31 August 2017

This application has been prepared by Ethos Urban on behalf of Mirvac Projects Pty Ltd (Mircac), pursuant to section 96(1A) of the *Environmental Planning and Assessment Act 1979* (EP&A Act) to modify Development Consent SSD 7317 which relates to the development of a commercial campus at the Australian Technology Park, Eveleigh.

The purpose of this modification request is to seek approval for the placement of mechanical exhausts, flues, vents and photovoltaics on top of the roof of Building 1 and amend the wording of Condition A14 accordingly.

Sheet No. 3 of 4

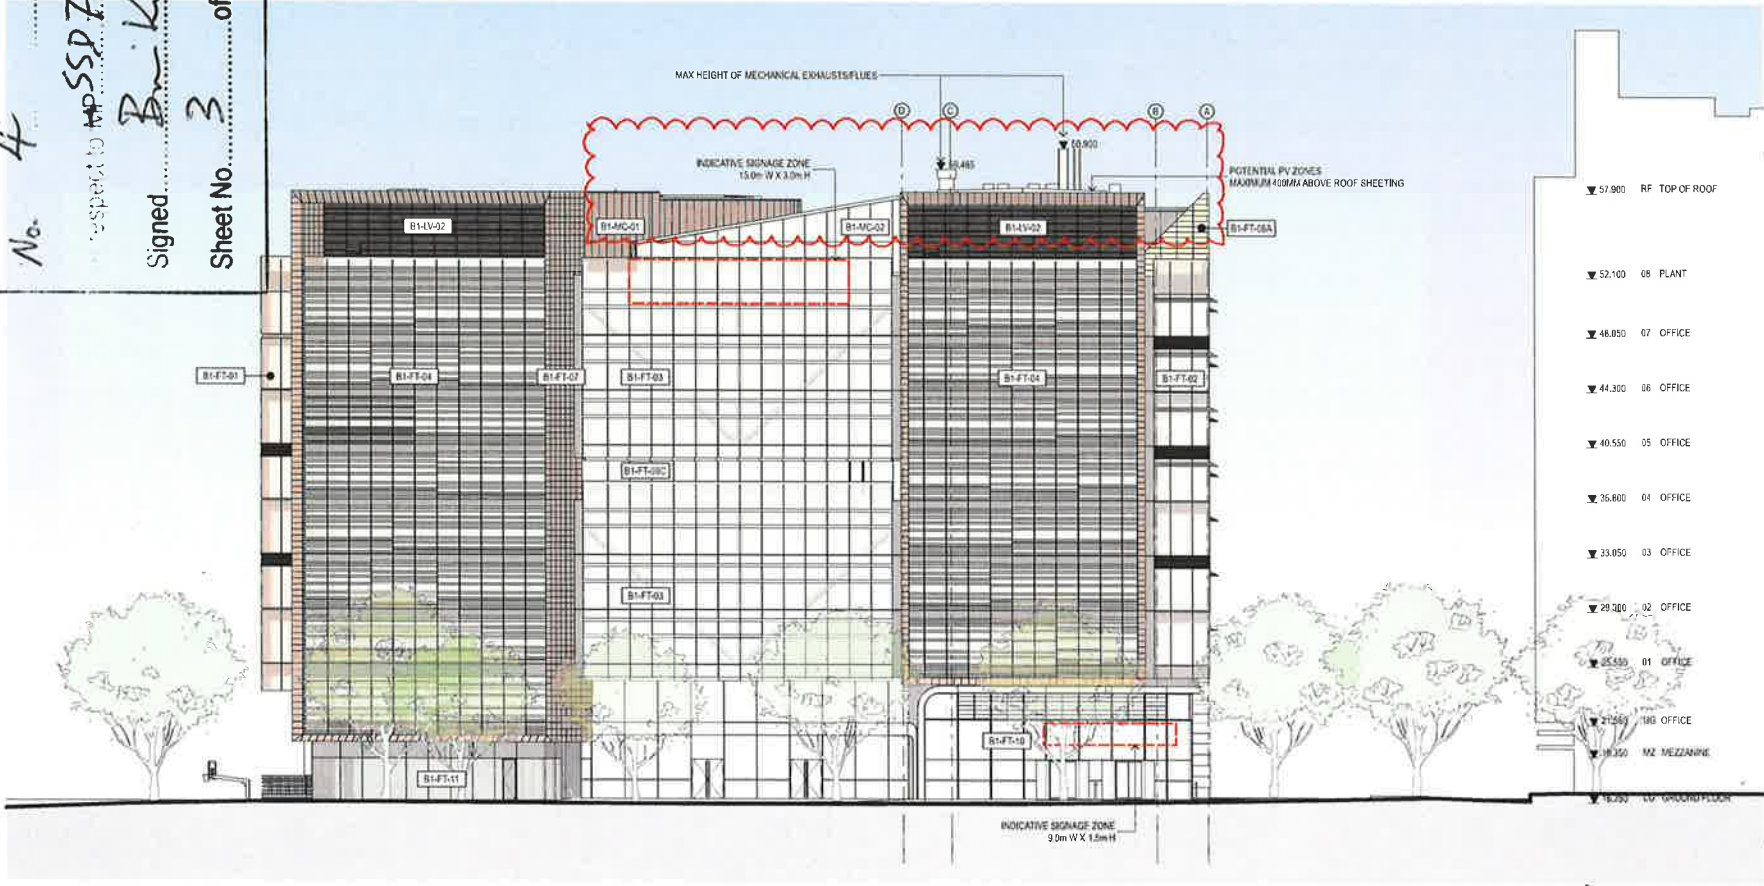
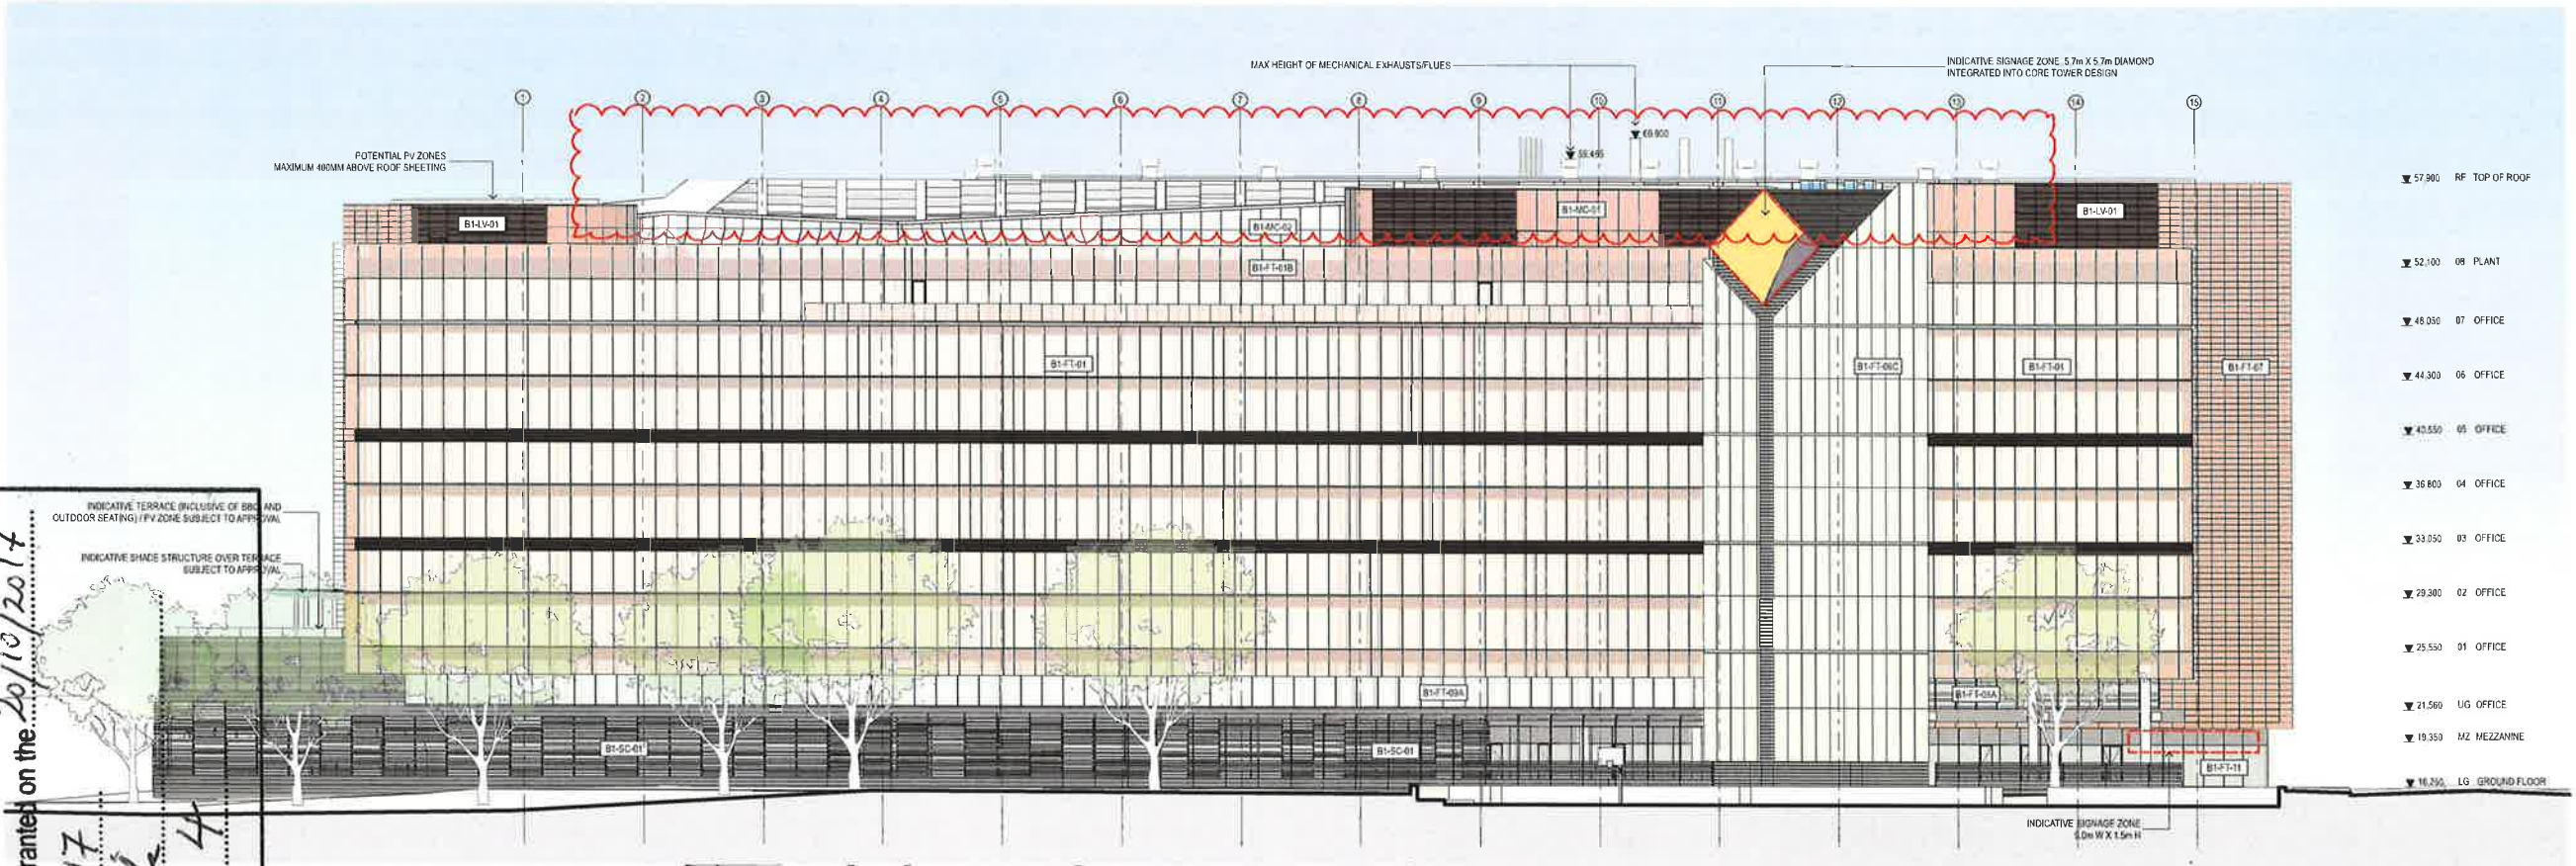
<b>Drawing No.</b>	<b>Rev</b>	<b>Name of Plan</b>	<b>Date</b>
<b>Fjmt-AR-DWG-11008</b>	<b>DA1</b>	<b>Level 08 Plant GA Plan</b>	<b>27.04.16</b>
<b>Fjmt-AR-DWG-11009</b>	<b>DA1</b>	<b>Roof Plan</b>	<b>27.04.16</b>
<b>Fjmt-AR-DWG-11050</b>	<b>DA4</b>	<b>Elevations – South &amp; East</b>	<b>22.03.17</b>
<b>Fjmt-AR-DWG-11051</b>	<b>DA1</b>	<b>Elevations – North &amp; West</b>	<b>27.04.16</b>
<b>Fjmt-AR-DWG-11008</b>	<b>DA5</b>	<b>Level 08 Plant GA Plan</b>	<b>25.07.17</b>
<b>Fjmt-AR-DWG-11009</b>	<b>DA7</b>	<b>Roof Plan</b>	<b>25.07.17</b>
<b>Fjmt-AR-DWG-11050</b>	<b>DA7</b>	<b>Elevations – South &amp; East</b>	<b>25.07.17</b>
<b>Fjmt-AR-DWG-11051</b>	<b>DA7</b>	<b>Elevations – North &amp; West</b>	<b>25.07.17</b>
